CITY OF PORTLAND, MAINE

PLANNING BOARD

August 17th, 2012

Project Name: **Phase II Development Jordan's Meat site**
Project ID: 2012-491 CBL: 29-3-L
Address: 203 Fore Street, Portland
Applicant: Fore India Middle, LLC, Opechee Construction Corporation
Planner: Jean Fraser

FORE STREET LOWER LEVEL FLOOR PLAN
SCALE: 3/64" = 1'-0"

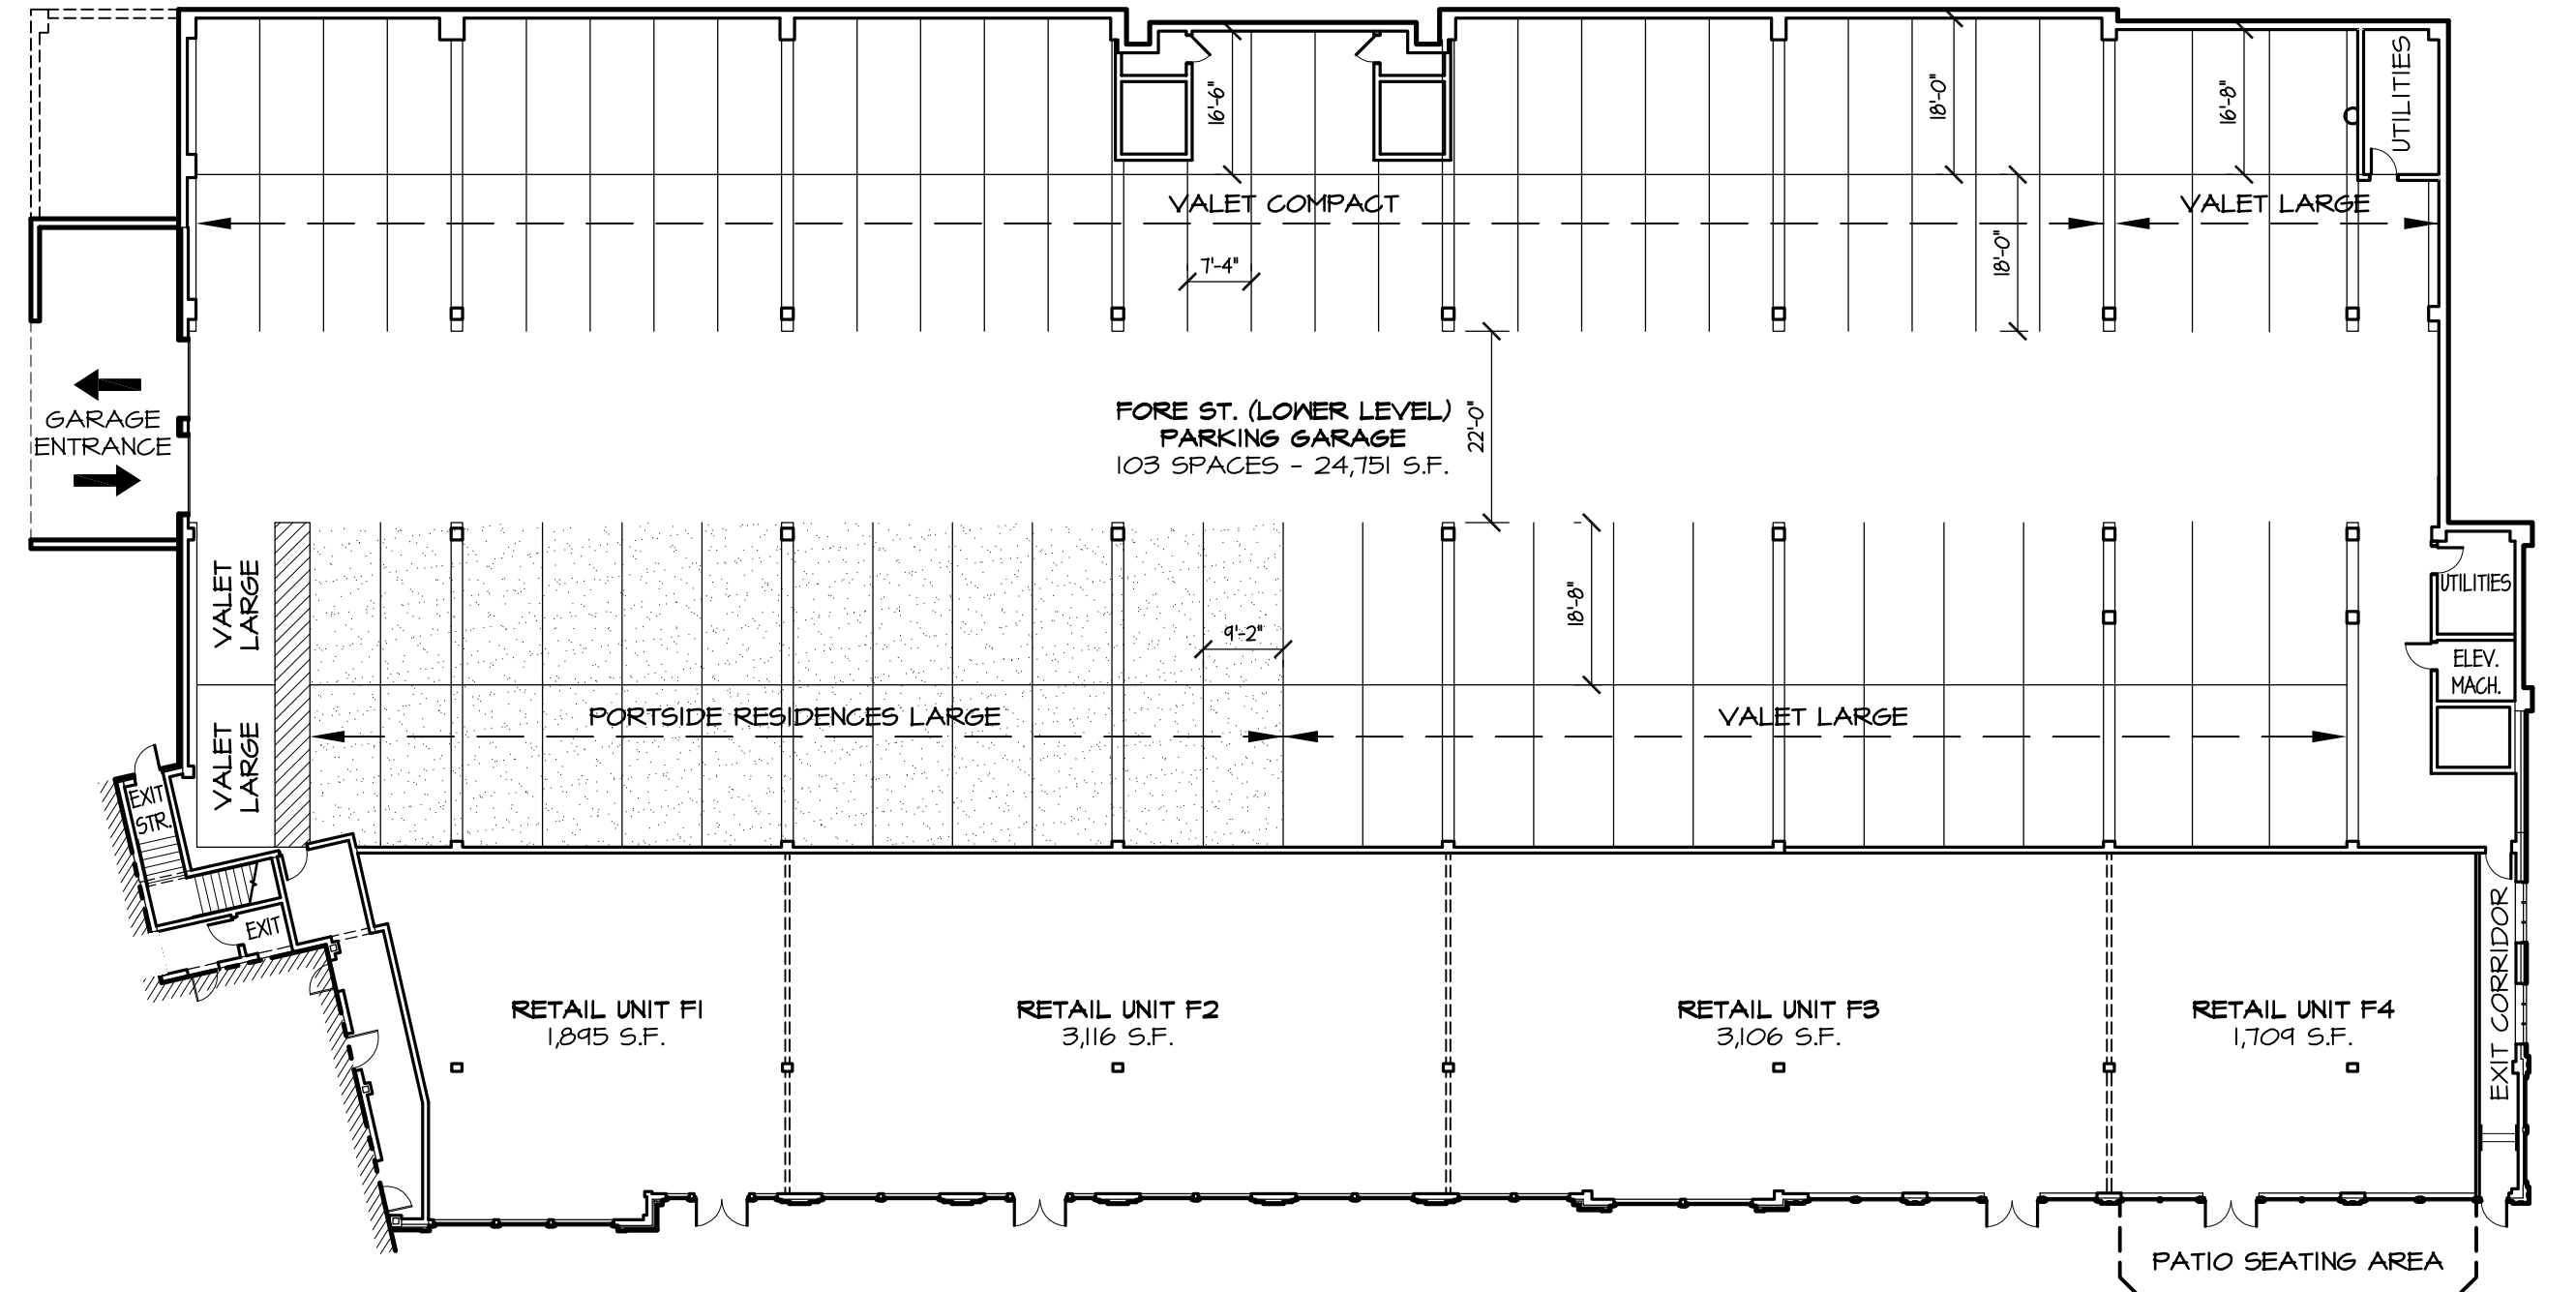
The Planning Board waives Technical Standard, Section 1.14, which allows parking lots with greater than 10 spaces to be comprised of up to 20% compact parking spaces, to allow 56 compact parking spaces in the Fore Street Garage (representing 49% of the spaces in the Fore Street garage and 31% of the total number of spaces in both garages that are within the Phase II development), subject to these spaces being only for 24-hour valet parking which would ensure appropriate use of the spaces.

The Planning Board waives Technical Standard, Section 1.14 which requires standard parking spaces to be 9 feet by 18 feet, to allow slightly smaller or larger spaces to take account of the columns and tandem parking arrangements as shown on approved Plan C11 (Plan 13 to this Report), subject to “valet compact” spaces being controlled by 24-hour valet operation.

The Planning Board waives Technical Standard, Section 1.14 which requires compact parking spaces to be 8 feet by 15 feet, to allow the 56 compact spaces in the Fore Street garage (valet –parked) to be slightly smaller or larger to take account of the columns, tandem parking arrangements and because they will only be used for 24-hour valet parking as described in the *Updated Parking Study* and shown on approved Plan C11 (respectively C.3 and Plan 13 to this Report).

The Planning Board waives Technical Standard, Section 1.14, Figure I-27 and I-29 which requires a 24 foot wide drive aisle, to allow the reduction to 22 feet in both garages to accommodate structural columns, based on the parking use being limited to 24-hour valet and regular users where depicted on the approved Plan C11 (Plan 13 to this Report).

- o The applicant is proposing parking aisle widths that will be narrower (22 feet vs. 24 feet) than City standards require. While parking maneuvers will be tight, I support a waiver given that the Fore Street parking level will involve experience valet parking personnel, and the Middle Street parking lot is relatively small and slow vehicle maneuvering activity should not result in widespread issues.

- o Some parking spaces on the Middle Street level exceed the width standard (9.5 feet vs. 9 feet) allowed and therefore a waiver is required. Given that structural support columns are located in the areas where these wider parking spaces are proposed, I support a waiver from the City Technical standards.

- o Some parking spaces in the India Street level exceed the width standard (9 feet 2 inches vs. 9 feet) and a waiver is required. I support a waiver from City standards.

- o Some parking spaces in the India Street level exceed the length standard (18 feet 8 inches vs. 18 feet) and a waiver is required. I support a waiver from City standards.
